Medworth Energy from Waste Combined Heat and Power Facility

PINS ref. EN010110
Document Reference: Vol 9.5
Revision 1.0
Deadline 1: 10 March 2023

Statement of Common Ground between Medworth CHP Limited and Walsoken Parish Council

Figure 8.3
Modelled Receptors

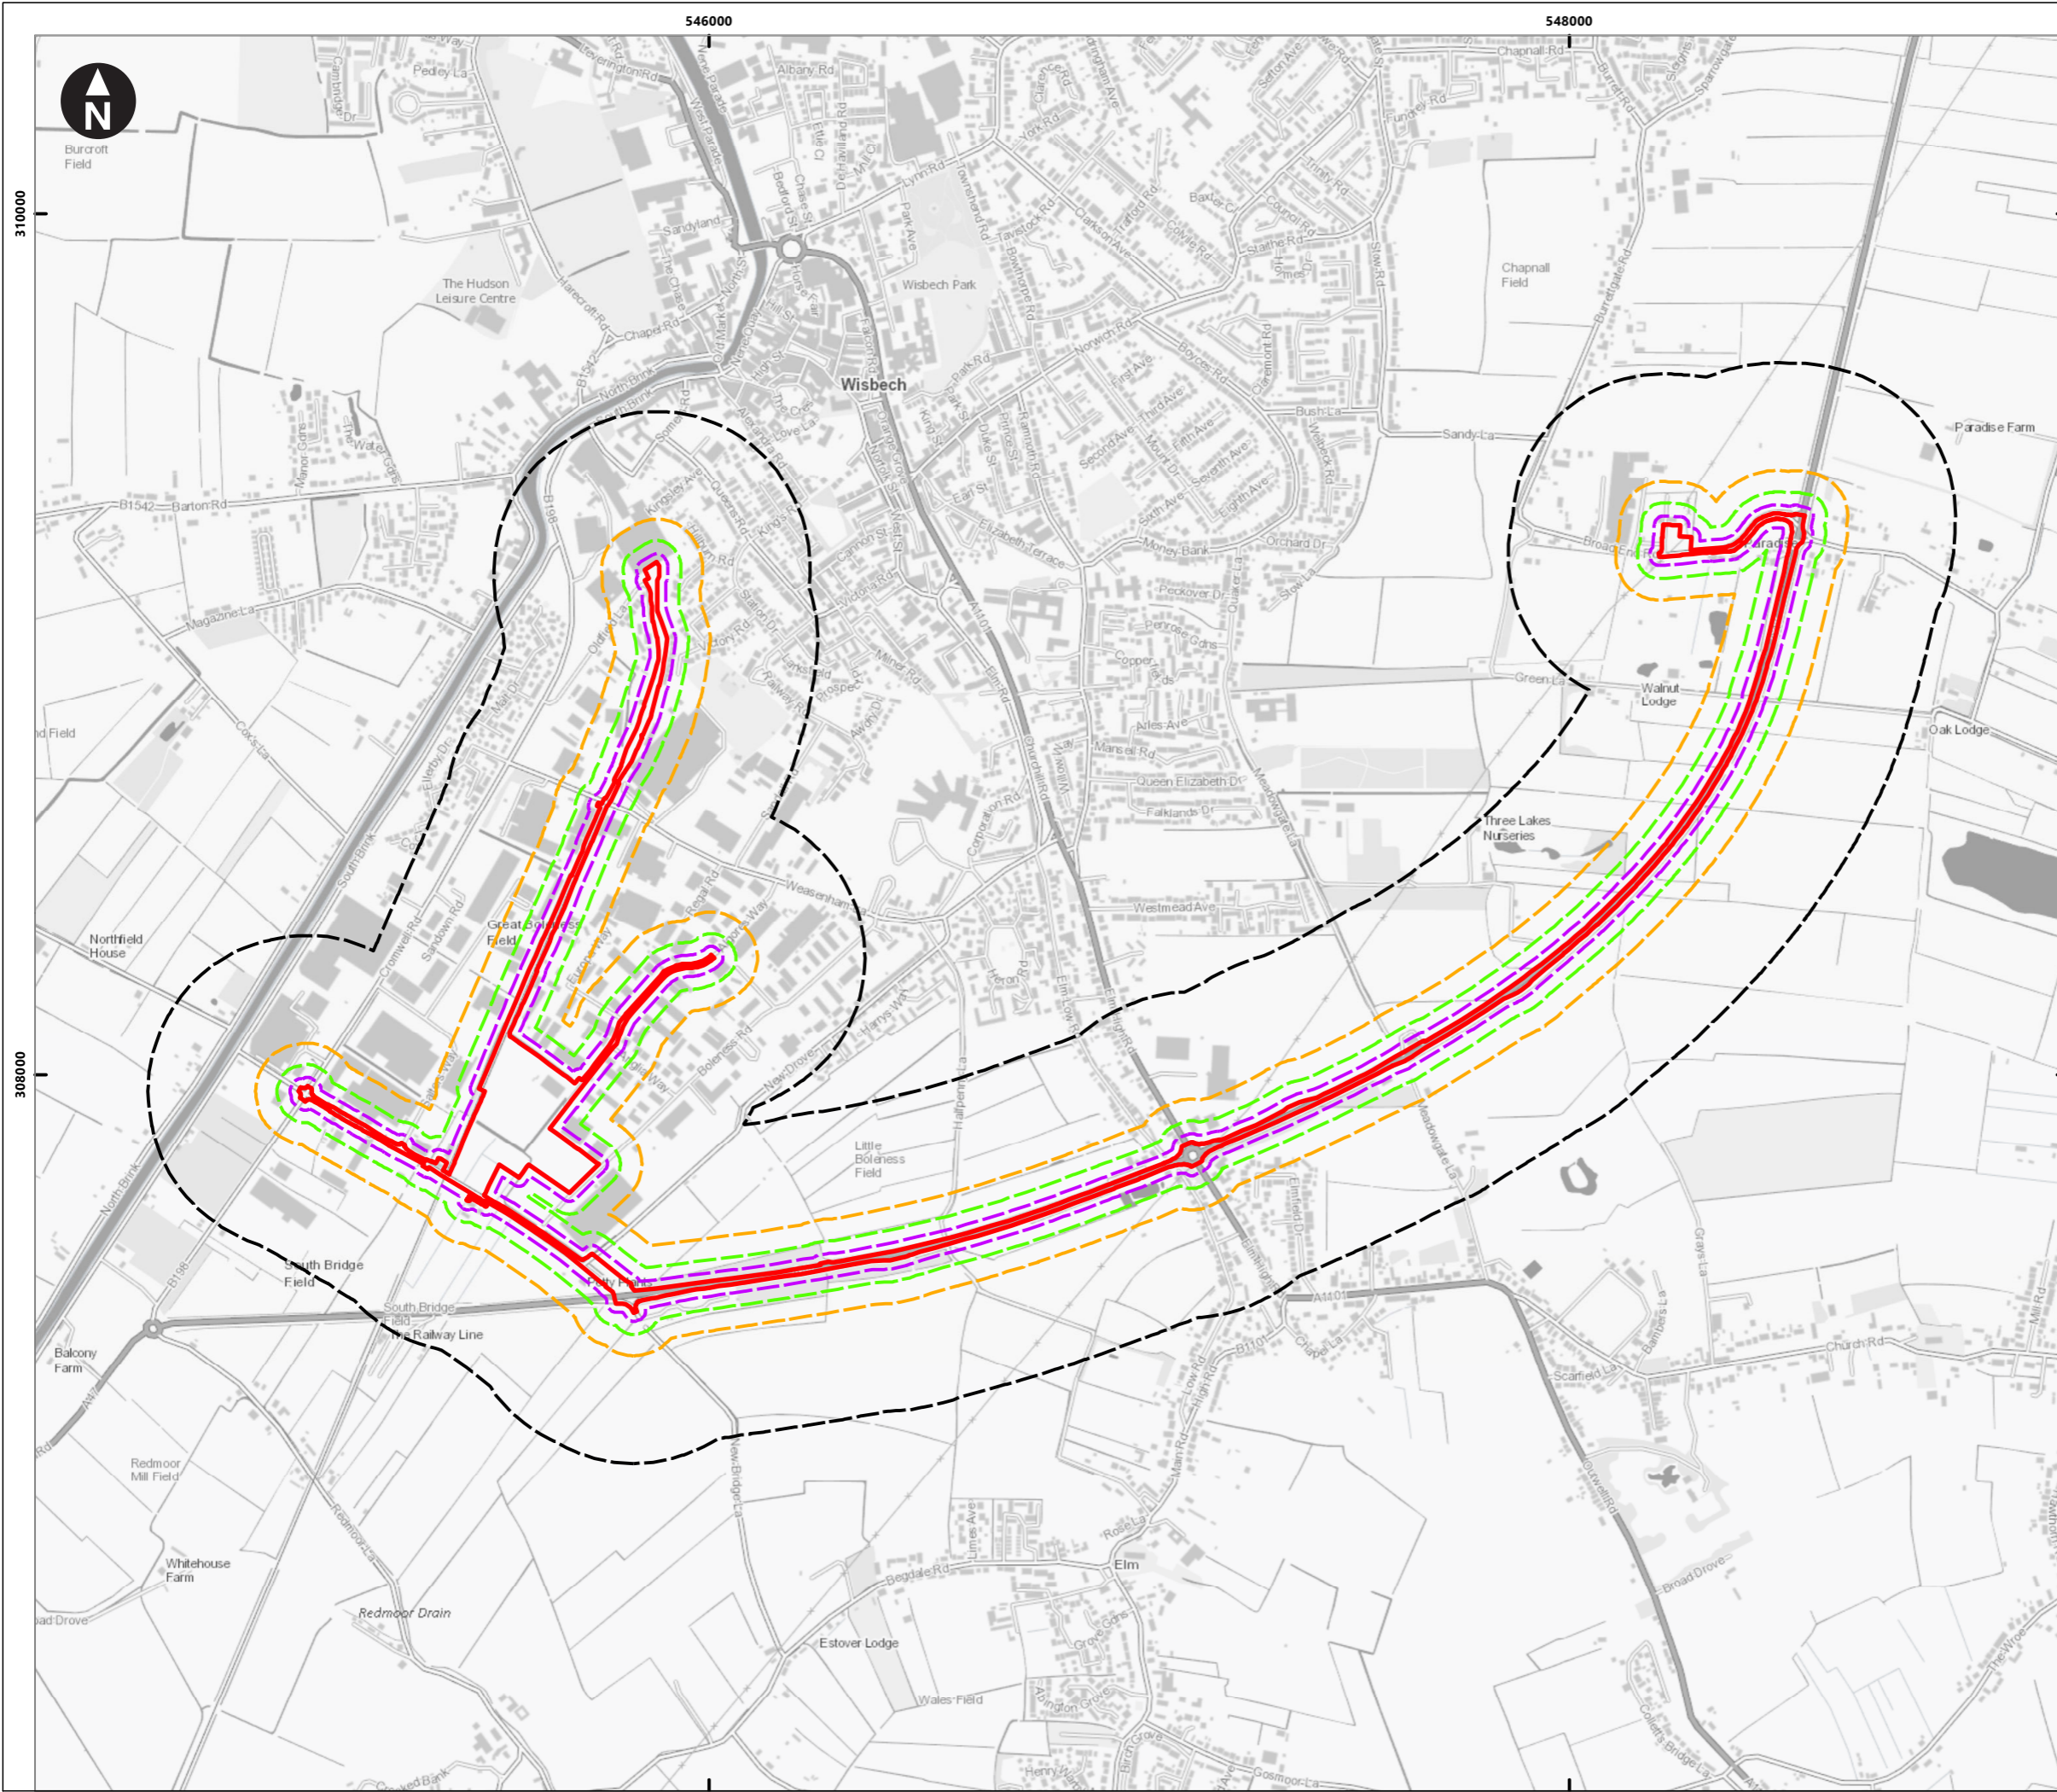
3.9.4	The air quality modelling includes residential receptors within Walsoken Parish (references R331, R332, R336, R337 and R338 as shown on Figure 8.3 in the Air Quality Figures of ES Chapter 8: Air Quality (Volume 6.3) [APP-052]).		Walsoken Parish Council confirms that it is not in a position to agree the accuracy of this information.

3.9.5	The nearest receptors to the community of Walsoken Village, shown on Figure 8.3 of ES Chapter 8: Air Quality (Volume 6.3) [APP-052] are: R93, R301 and R310.		Walsoken Parish Council confirms that it is not in a position to agree the accuracy of this information.
